From: Martyn White
Sent: 18 May 2018 15:45
To: David Easton
Subject: FW: Y/92/17/OUT

The proposal forms an area of land at the edge of Yapton village. I note that the application forms part of the potential strategic housing allocation in the emerging Arun Local Plan 2011-2031 (ALP).

FIGURE 36. Plan showing the site in relation to the Yapton Conservation Area and Listed Buildings

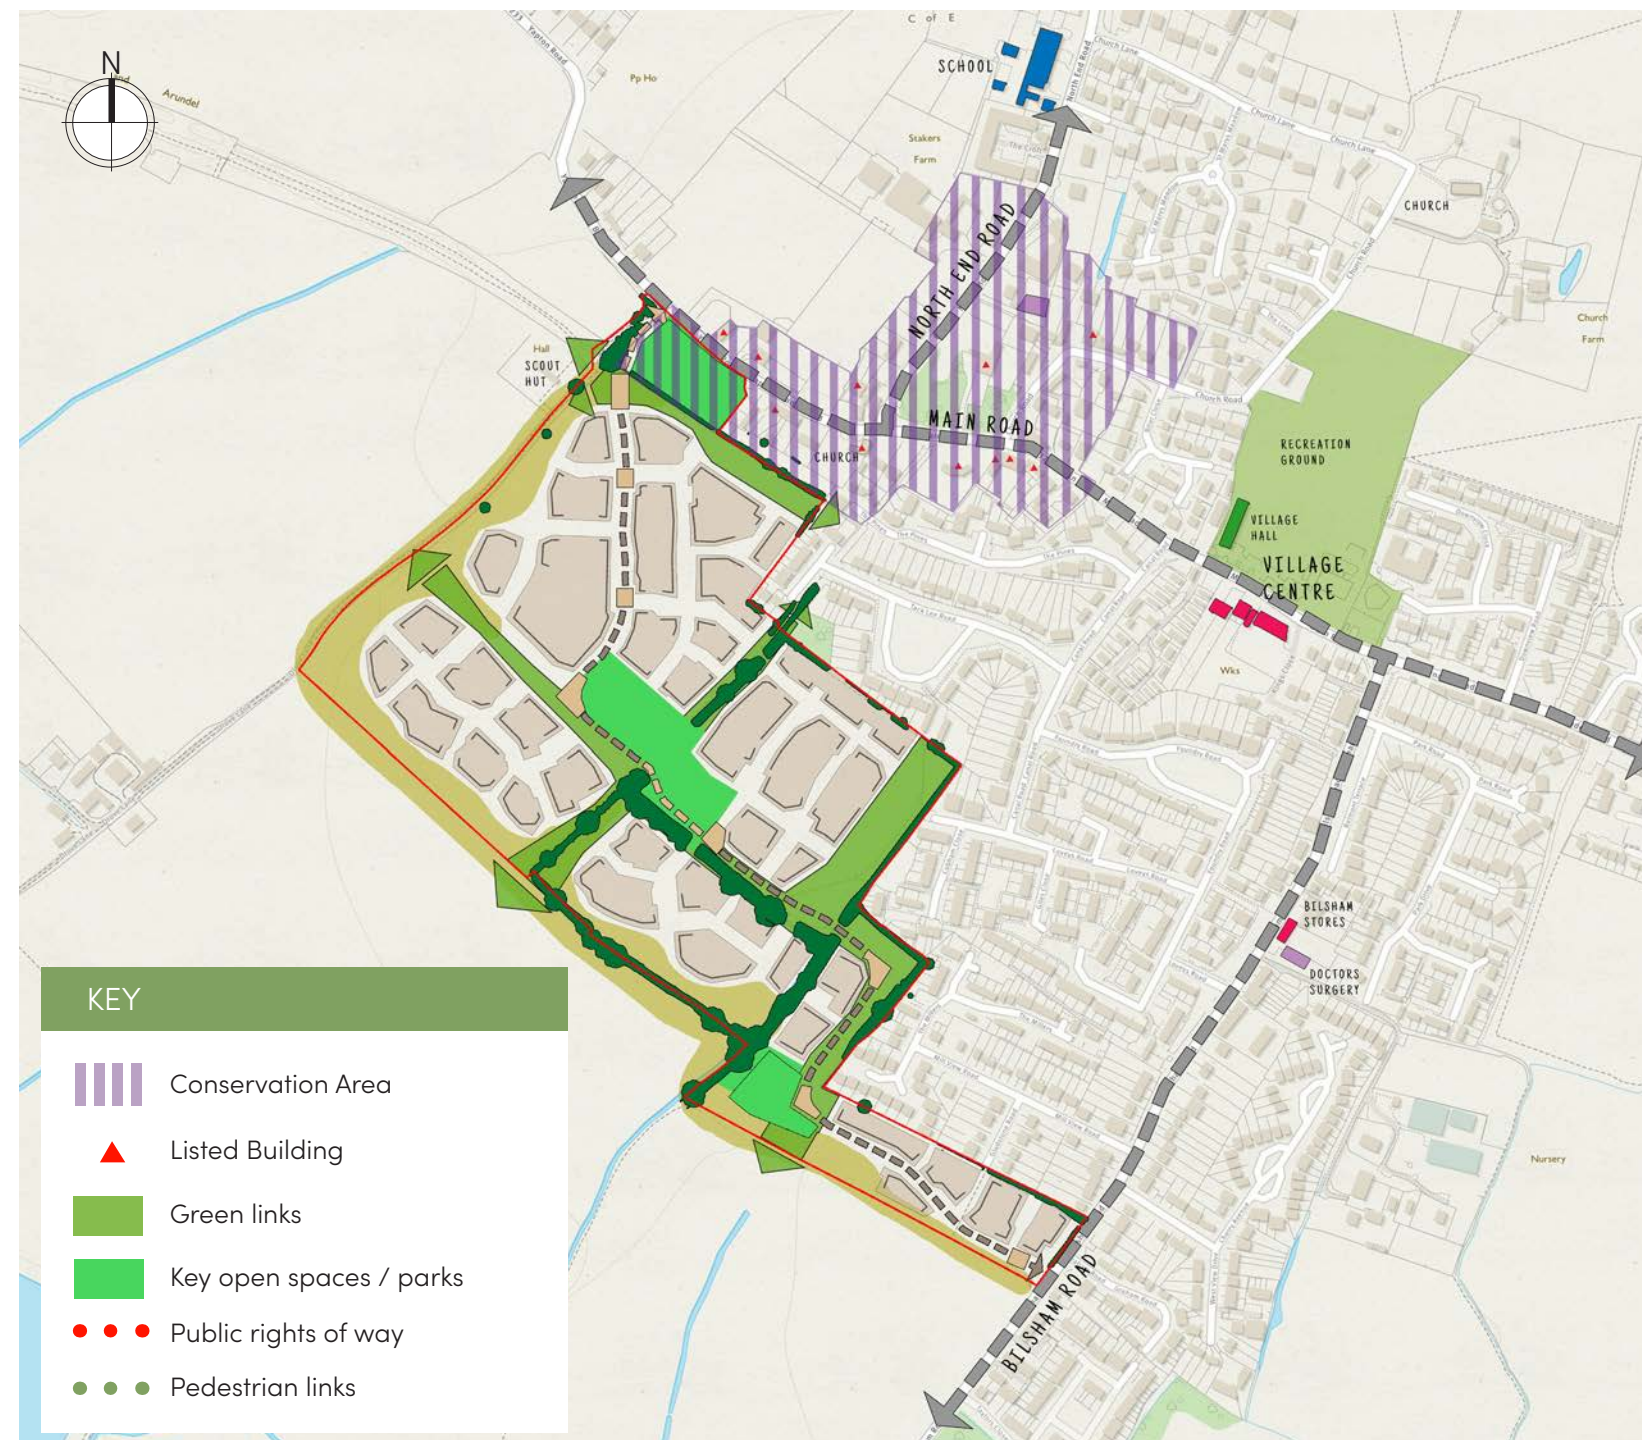
It is considered that more detailed information should be provided with regards to the impact of the proposed development on the conservation area and its setting – it is not clear if any consideration has been given to the views to or from the site. For instance when travelling in to the conservation area, will development be visible from the carriage way? The sectional information implies that there may be some impact? The character of the area is derived from the low density form of development, which maintains a rural characteristic.

It is questioned if there will be sufficient screening etc. to mitigate any impacts? It is not clear from the Heritage statement if this is the case.

FIGURE 54. Proposed access arrangements for the site

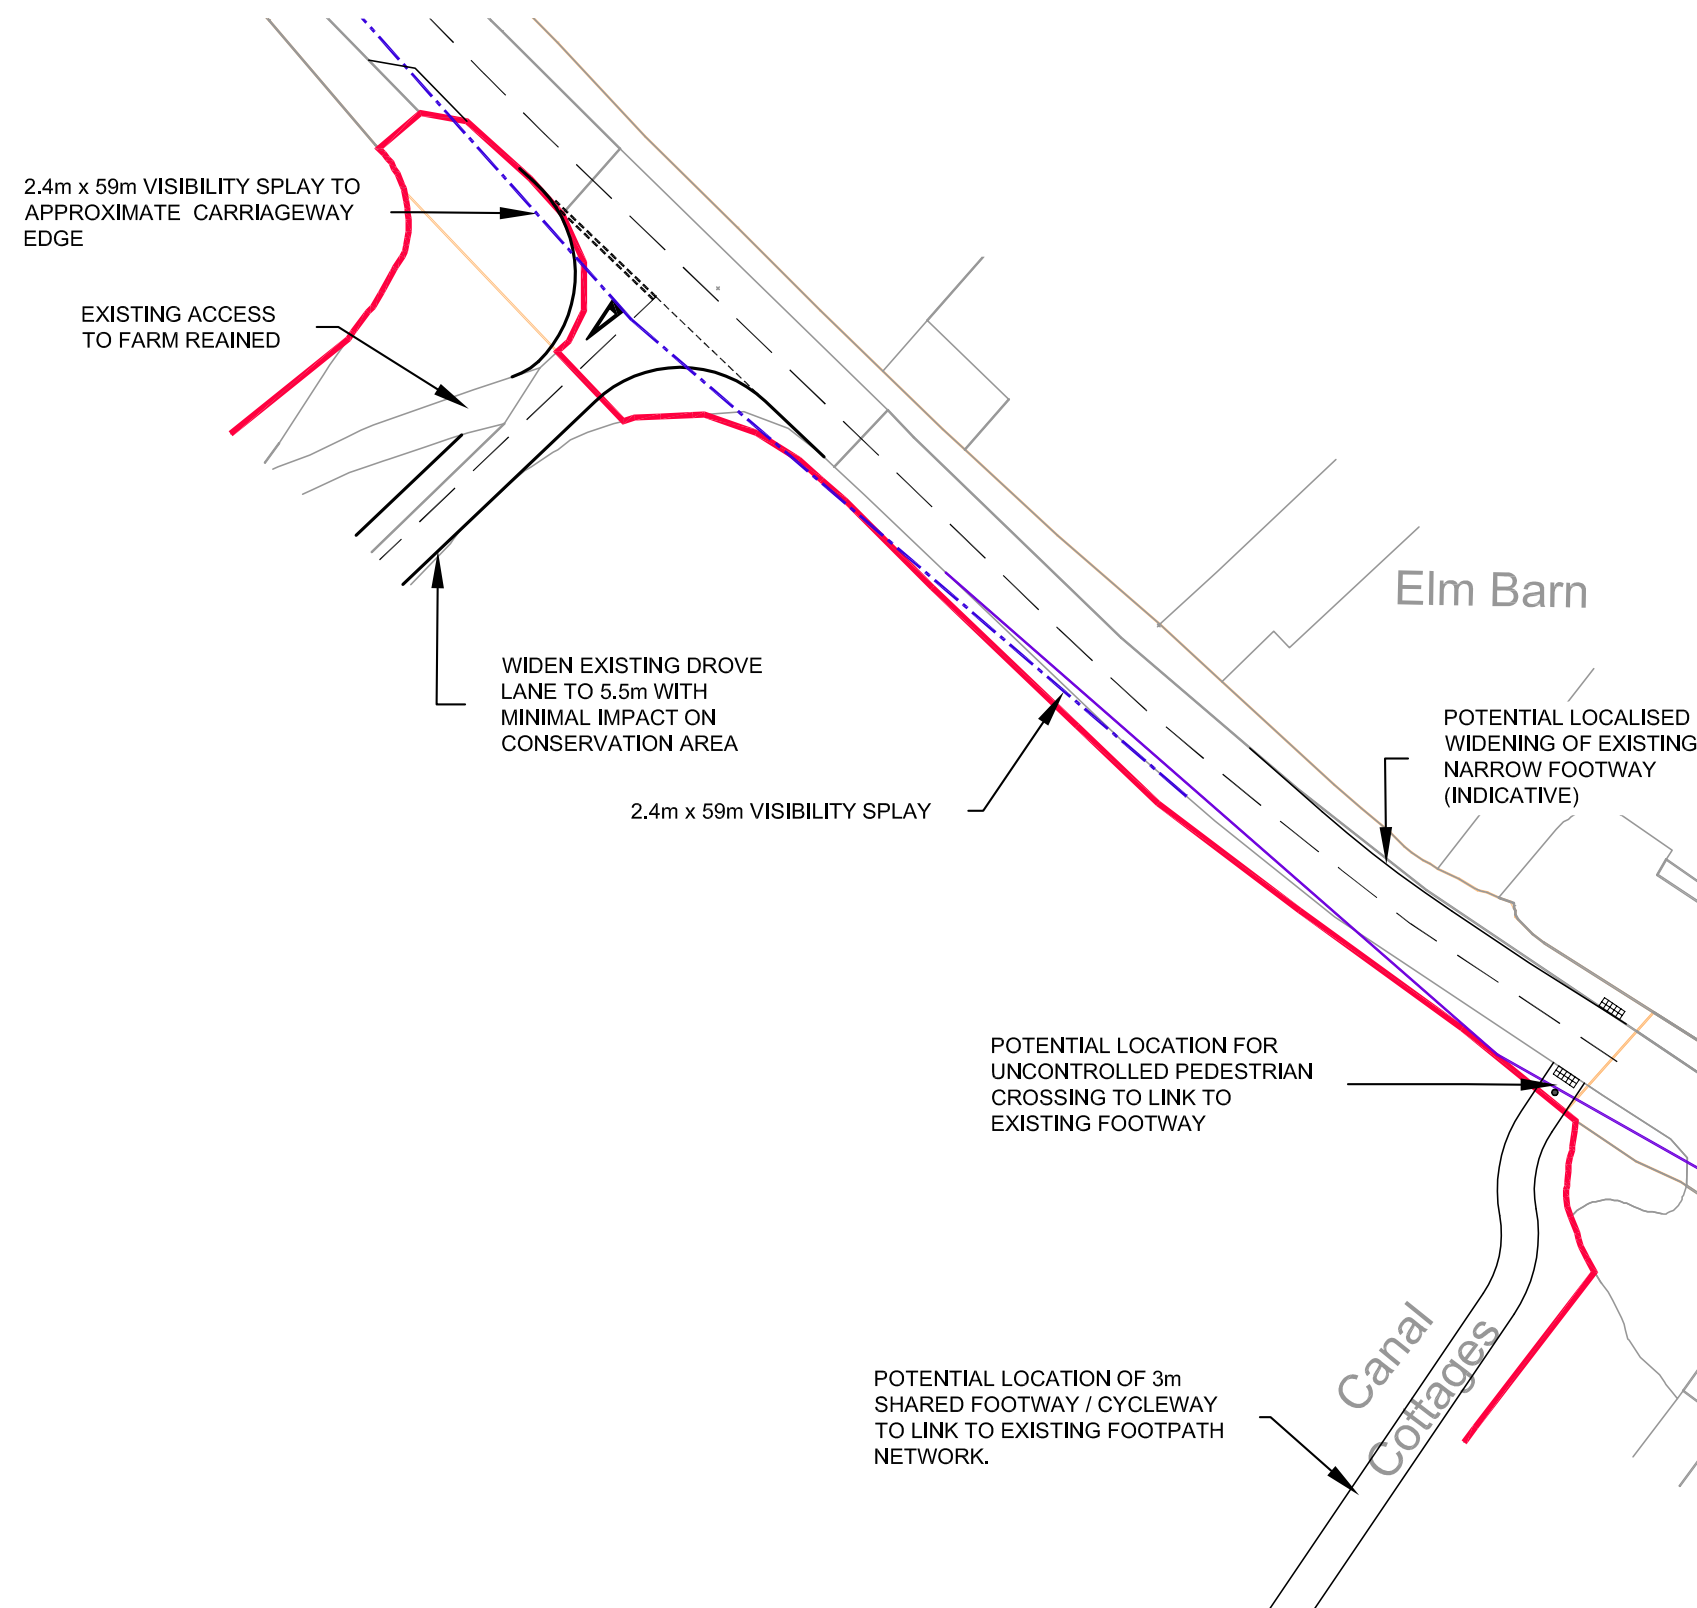
In addition, it is not clear if full consideration has been given to the impact of development via the new access and emergency access road. How will a new road and access road, along with the associated infrastructure affect the character of the area, where there currently is one small lane, with a limited number of street lights? Also how will the roads impact the route of the canal?
